Medworth Energy from Waste Combined Heat and Power Facility – Written Summaries of Oral Representations Made by CCC and FDC at Issue Specific Hearing 2 and Compulsory Acquisitions Hearing 2 (CAH2)

This document summarises the oral representations made by Cambridgeshire County Council (**CCC**) and Fenland District Council (**FDC**) (together, **the Councils**) at the Issue Specific Hearing 2 (ISH2) on Wednesday 12 April 2023 and oral representations made by CCC at Compulsory Acquisitions Hearing 2 (**CAH2**) on Thursday 13 April 2023 in relation to the application for development consent for Medworth Energy from Waste Combined Heat and Power Facility (the Scheme) by Medworth CHP Limited (the Applicant).

Table 1.1. Written Summaries of Oral Representations Made at ISH2 on Wednesday 12 April 2023

**Figure 10.1iv**  
**Cromwell Road/New Bridge Lane Signal Scheme - General arrangement**

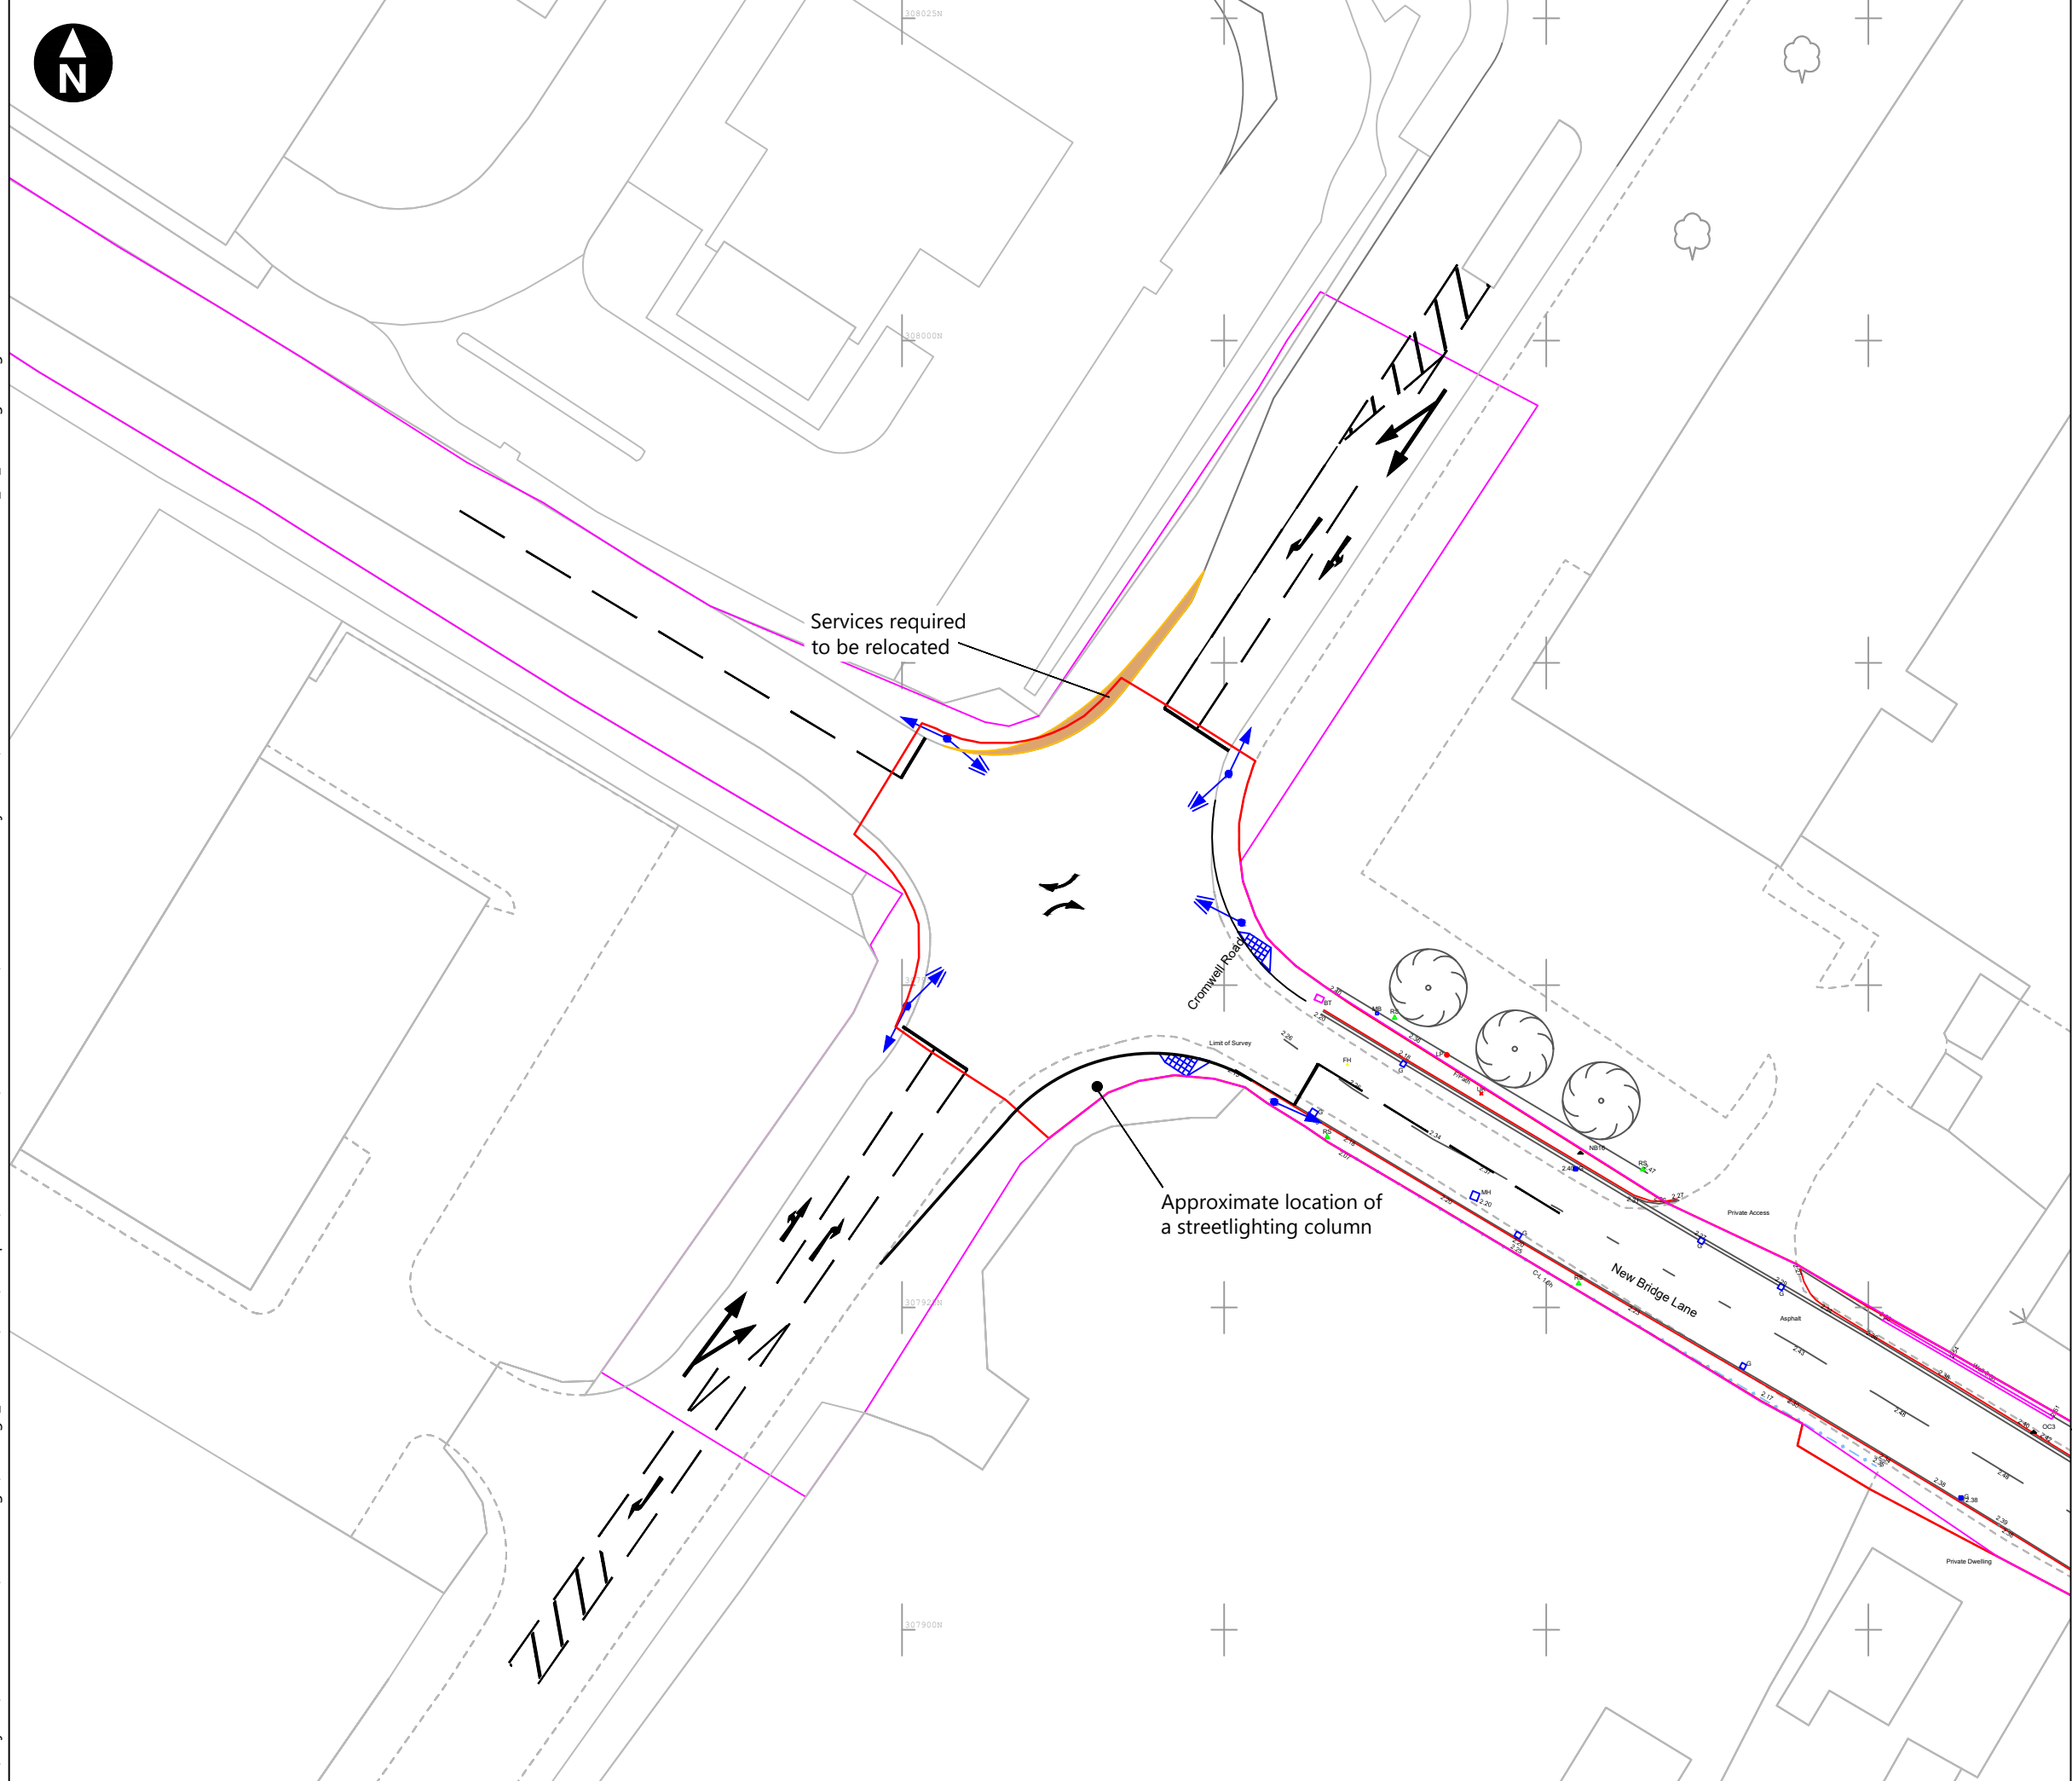
| Agenda Item | Cambridgeshire County Council's Submission |
|--|---|
| <p>4. Site specific representations by APs</p> | <p>CCC is of the view that in two areas, on New Bridge Lane and at the junction of New Bridge Lane and Cromwell Road, where there is to be a new signalised junction, the land which is to be acquired through this order is insufficient to bring about the development of the highway and the junction to the necessary standards. This is set out in the Councils' Joint Local Impact Report (LIR) [REP1-074], paragraph 2.7.19.</p> <p>CCC's Highways Development Manager referred to drawings in the Outline CTMP [REP1-011] in relation to CCC's concern regarding there being insufficient land take in the DCO to develop New Bridge Lane.</p> <p>From a technical perspective, the New Bridge Lane/Cromwell Road signalised junction design cannot be approved by the Local Highway Authority in its current form, due to various geometric and safety issues identified by CCC's signals experts. CCC's Transport Assessment Manager shared a drawing of a similar junction which was produced by CCC on behalf of FDC for the Wisbech Access Study, in order to demonstrate the difference in land take proposed by the Applicant compared to this design. The Council is concerned that there is insufficient land around the junction area to deliver an acceptable form of signalised junction. This plan has been submitted to the Examination as Appendix B [CLA.D3.OS.A.AB] to the Councils' Comments on the Applicant's D2 Submissions [CLA.D3.OS.A.C].</p> <p>The Council's Highways Teams are in discussion with the Applicant on this matter.</p> <p>The Council was asked to submit its comments regarding inaccuracies in the Book of Reference in writing. These comments were previously made in the Councils' response to the ExQ1 [REP2-030], in answer to CA.1.4 and CA.1.5. To CCC's knowledge, the Applicant is seeking to address these currently.</p> |
